Subject: 2023/93667 at location Storthes Hall Student Village, Storthes Hall Lane, Kirkburton, Huddersfield, HD8 0WA

Please see ecological commentary below.

Drawing SHF.1337.002.EC.D.002 – Preliminary Bat Roost Assessment

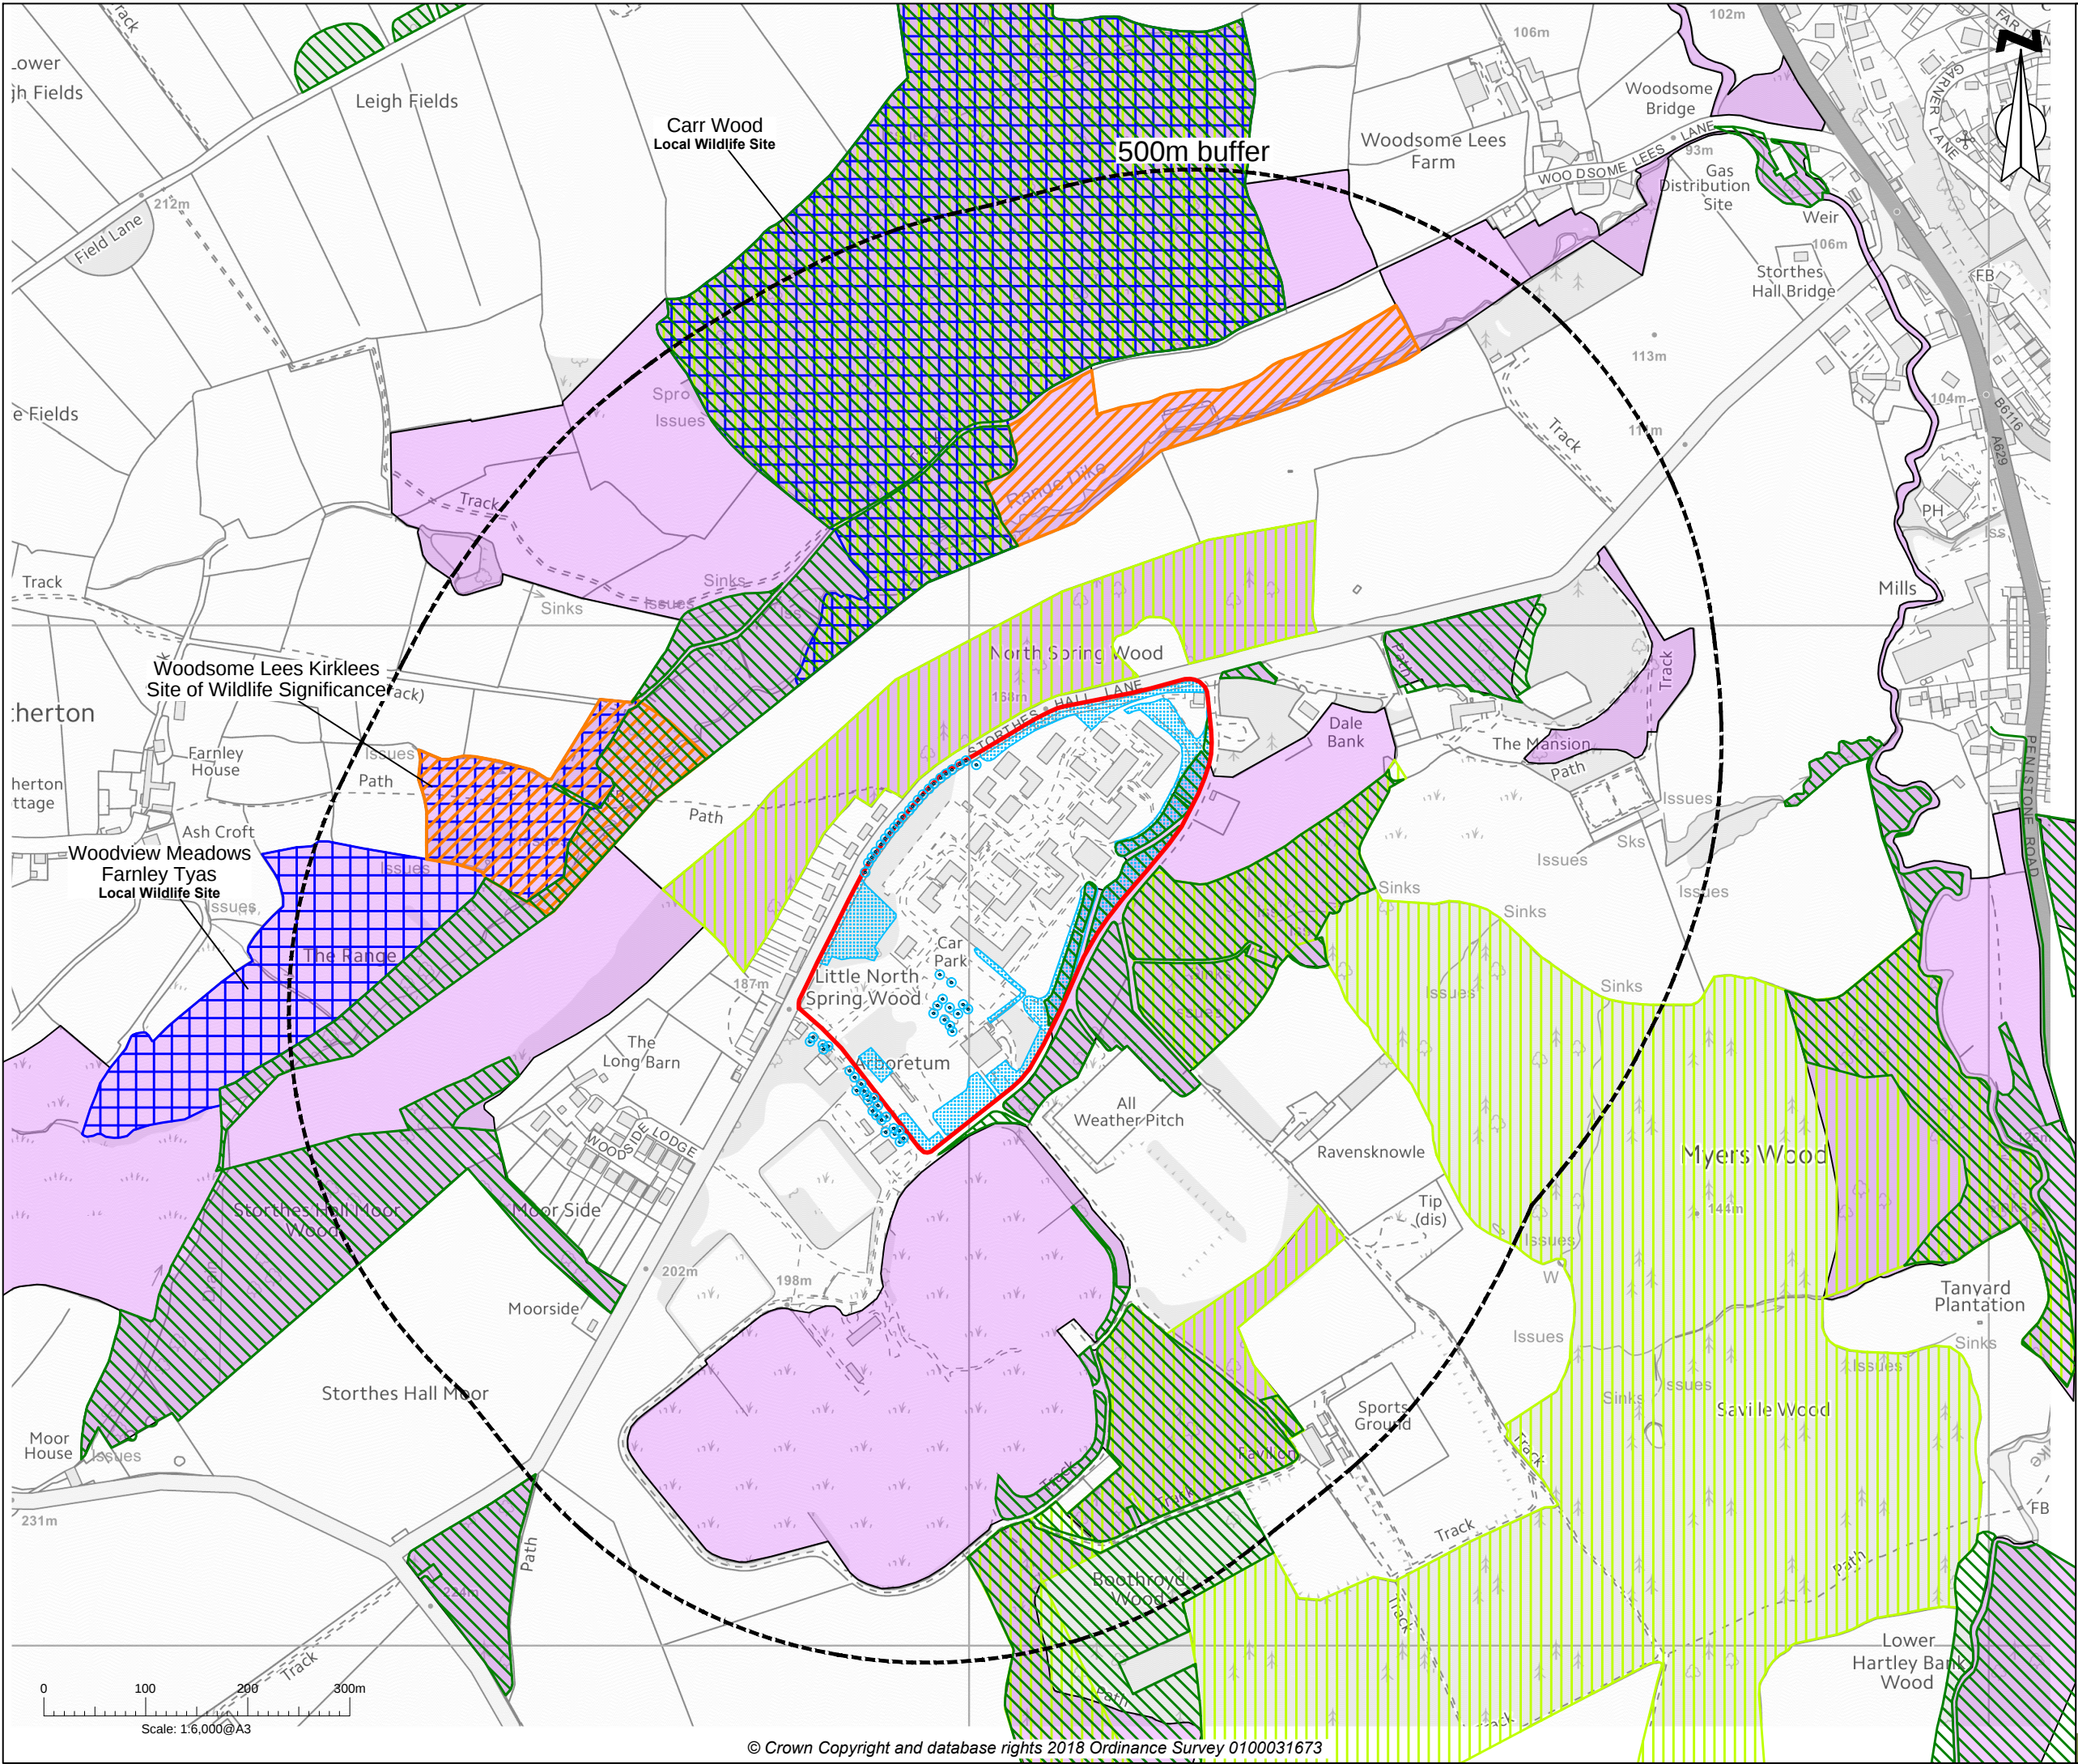
The report is reasonable and acceptable. The report confirms bat roosts in Buildings 2, 3, 8, 13, 16, 18, and 20. An EPS Mitigation Licence must be attained prior to any works on these buildings.

Furthermore, to prevent any major disturbance or potential death/injury of roosting bats, works may not proceed on buildings that are attached, or within close proximity, to buildings with recorded roosts. These buildings include 7, 14, 15 and 19.
